Address: 2, Victoria Road, Liversedge, Wf15 7Dw

Application number: 2026/90127	
What is the application for?:	Demolition of existing garage, outbuilding and porch and erection of two storey
Address of the site or building:	Squirrel Lodge, 19, Liversedge Hall Lane, Liversedge, WF15 7DP
Postcode:	WF15 7DP

Type of comment: An objection	
Do you wish your comments to be published on the website anonymously?	No

| Address | Squirrel Lodge, 19 Liversedge Hall Lane, Liversedge, WF15 7DP | Proposed plans |

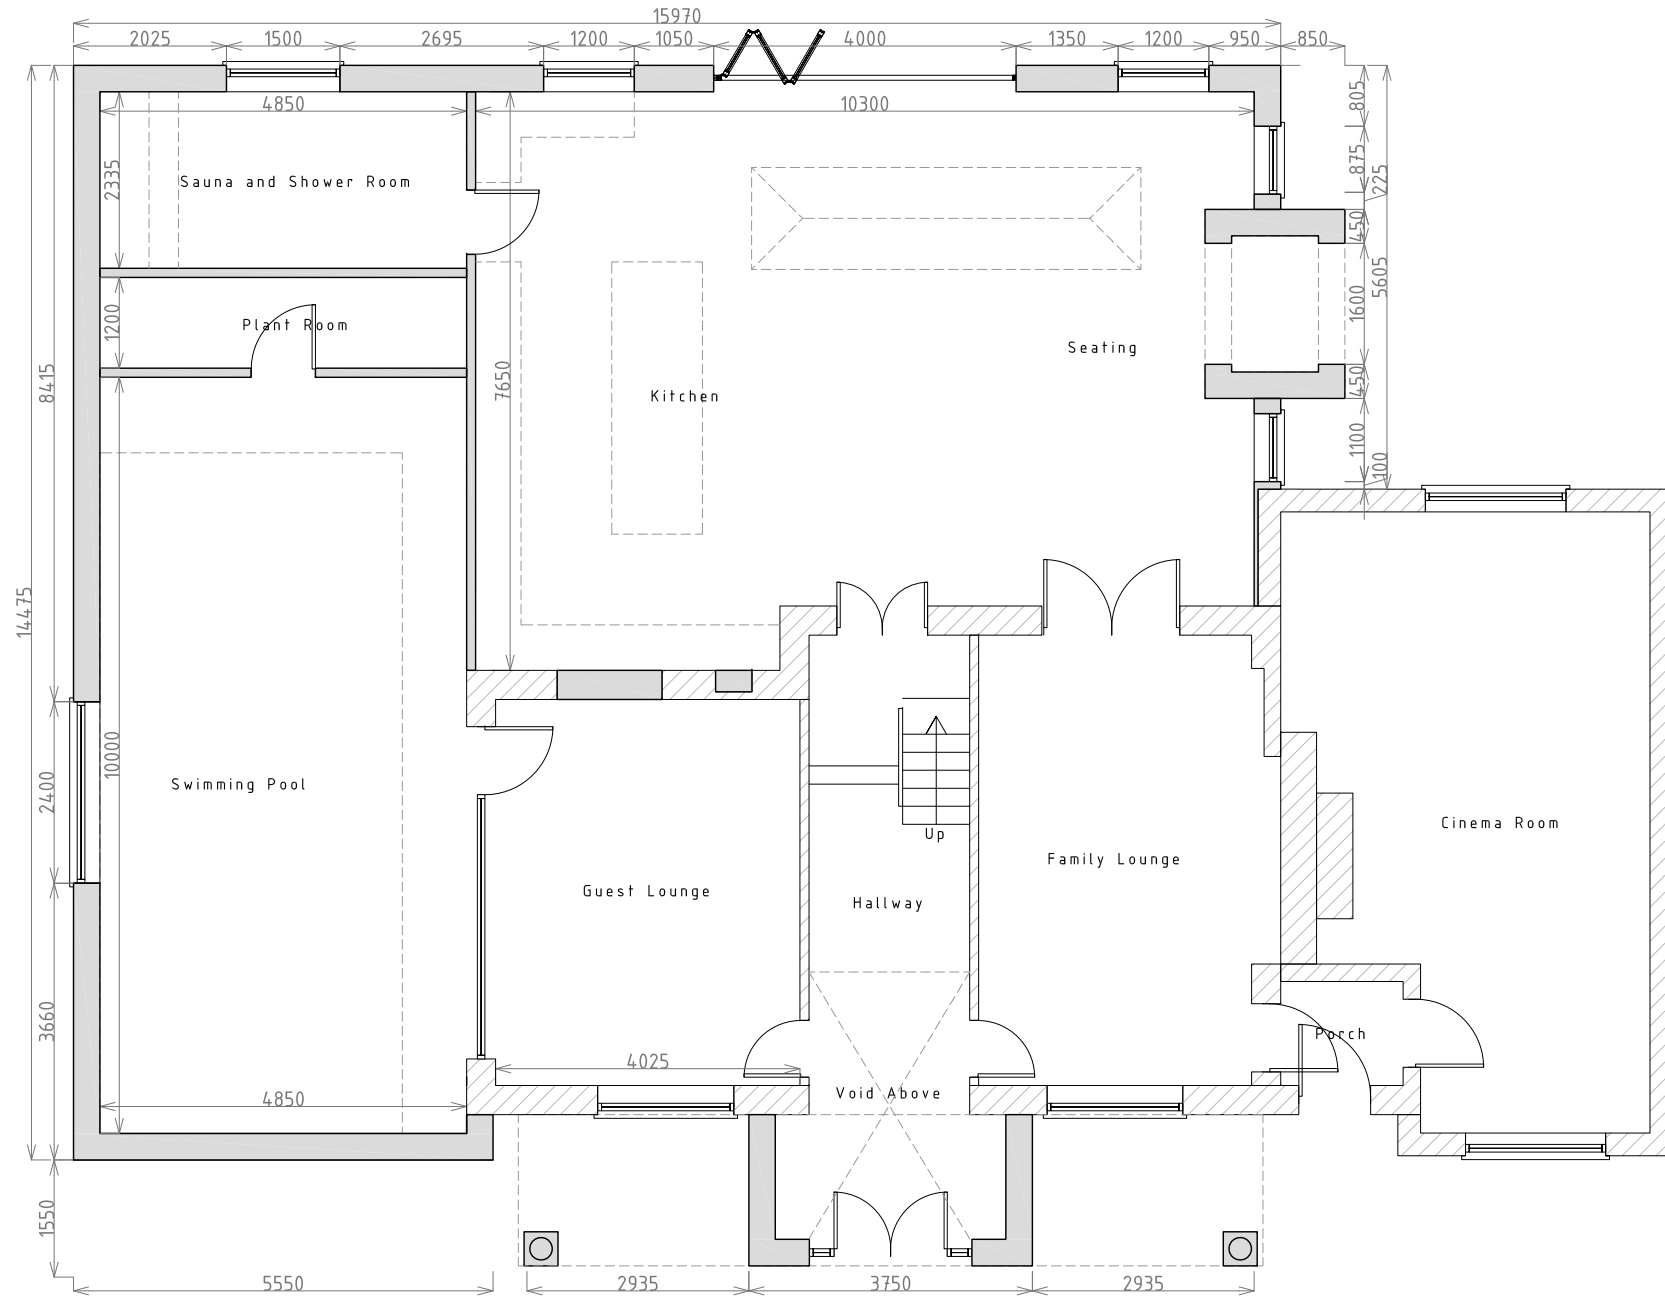
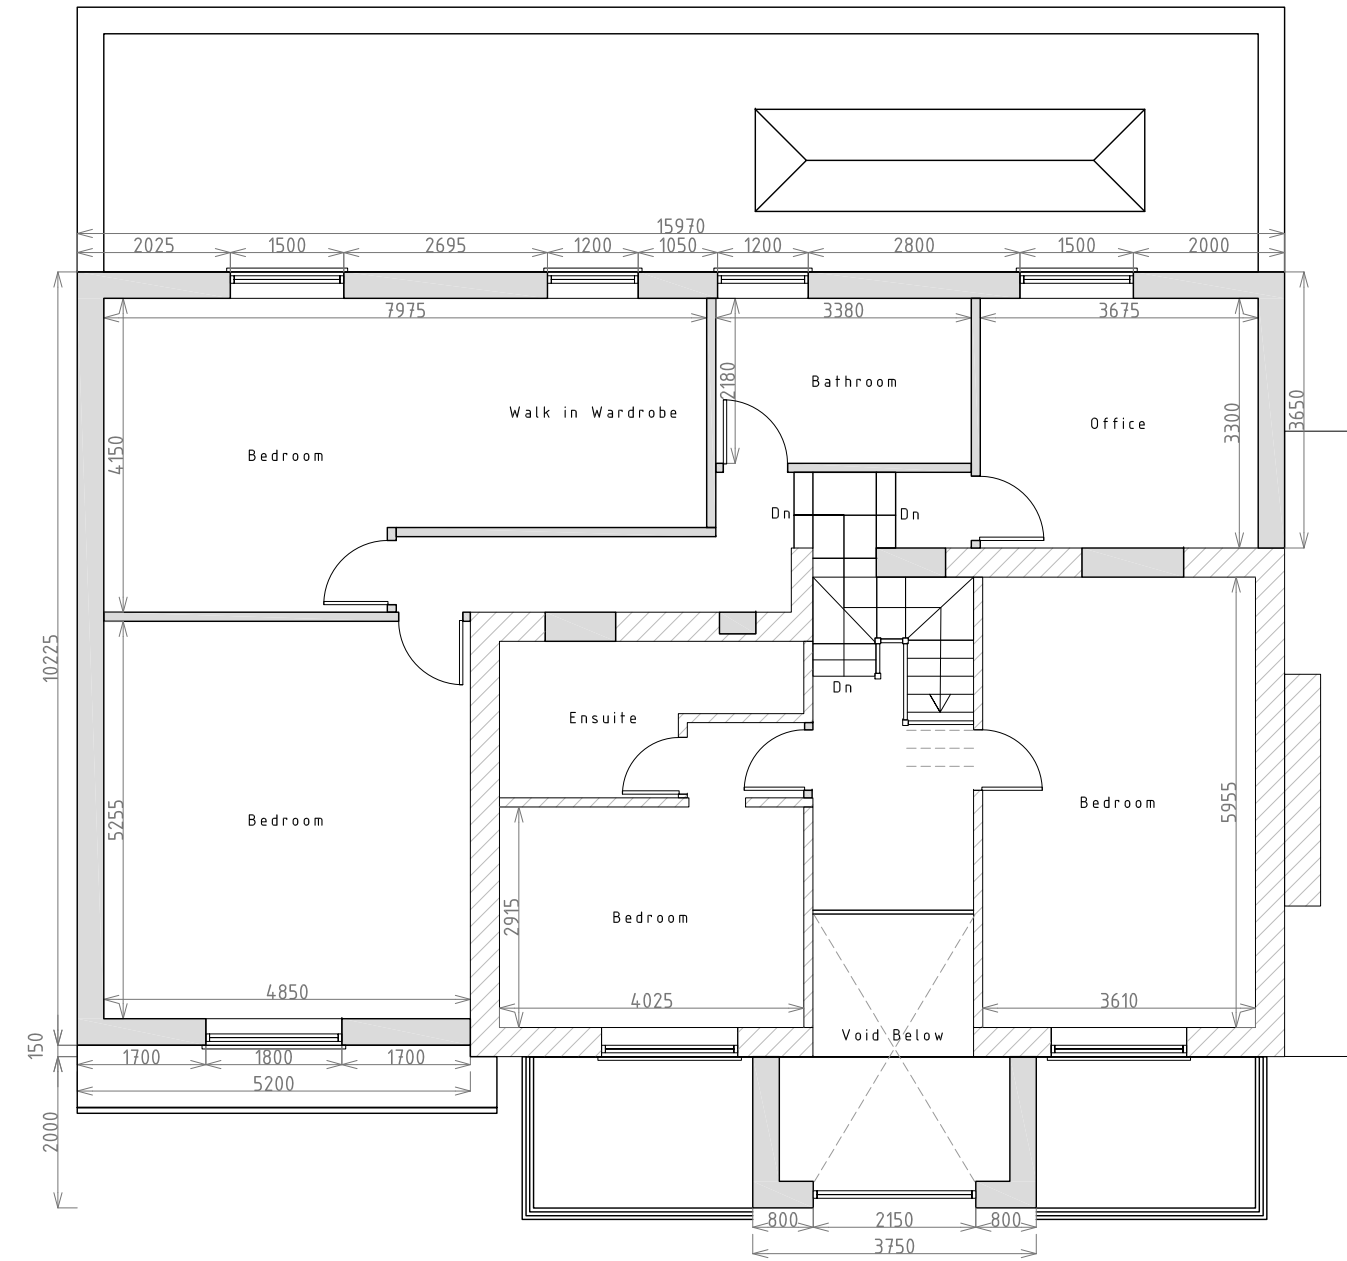
Our concerns are as follows: Overdevelopment and impact on the area - The proposed extension would be larger in footprint than the existing house, which feels excessive and out of proportion. It would significantly change the appearance of the property and would not be in keeping with the surrounding homes.

Loss of light and overshadowing. The proposed two-storey extension would run parallel to our home and come to within around three metres of our boundary.

Because of its height and position, it would block a significant amount of south-facing light to both our house and garden. This would result in noticeable loss of natural light and increased overshadowing.

Issue Purpose : HH Application		
Project	Proposed Single storey rear extension	Date 24-12-2025
		Scale 1:100 @ A3
Address	Squirrel Lodge, 19 Liversedge Hall Lane, Liversedge, WF15 7DP	Proposed Elevations
		D.N. 2025 - 19LHL - 07

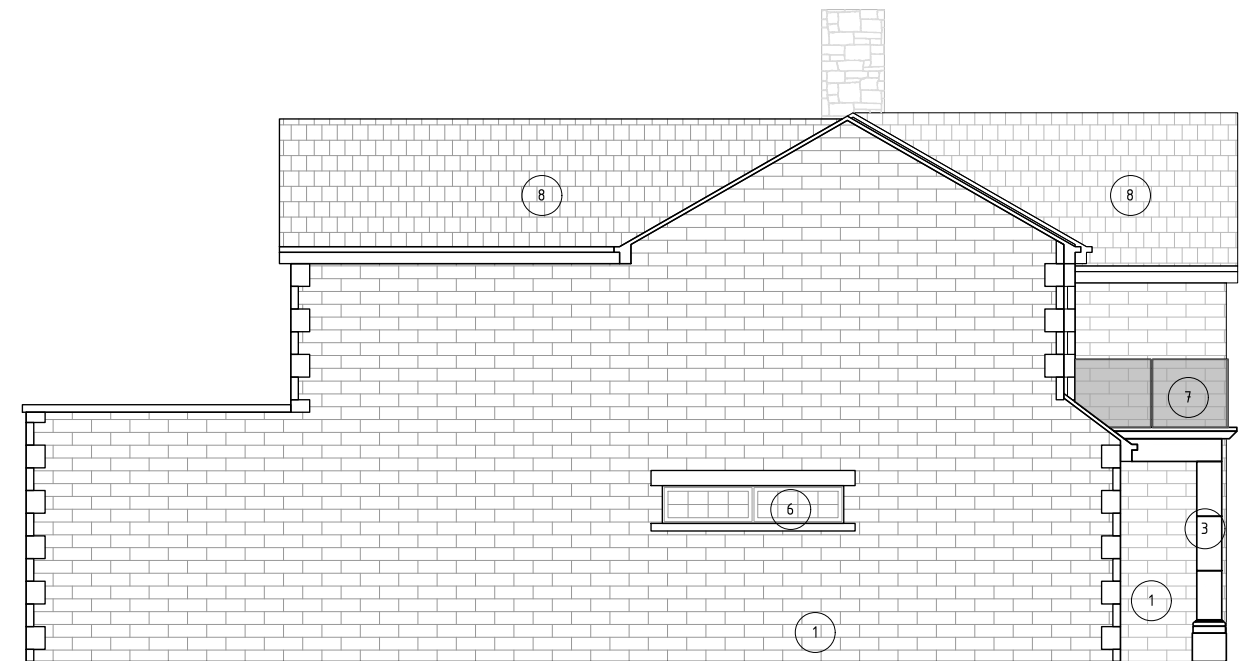
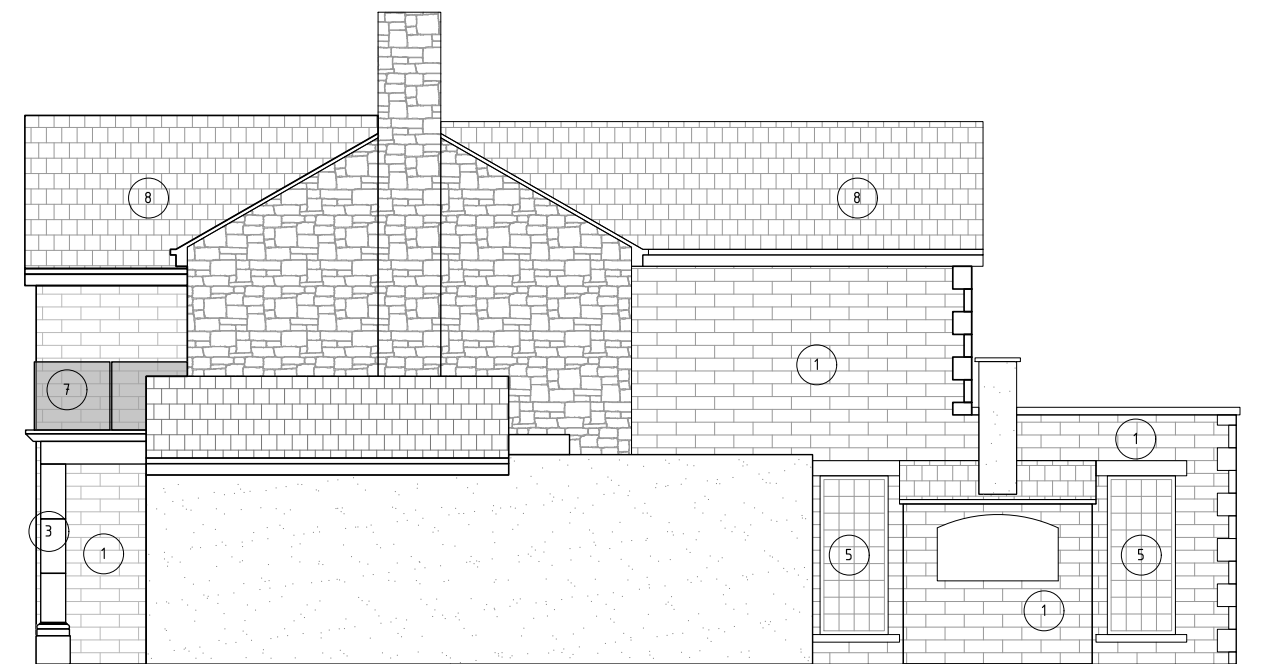
Loss of privacy. The plans show windows that would directly overlook our garden and into our home. This would seriously impact our privacy and affect our ability to enjoy our property/garden as we currently do.
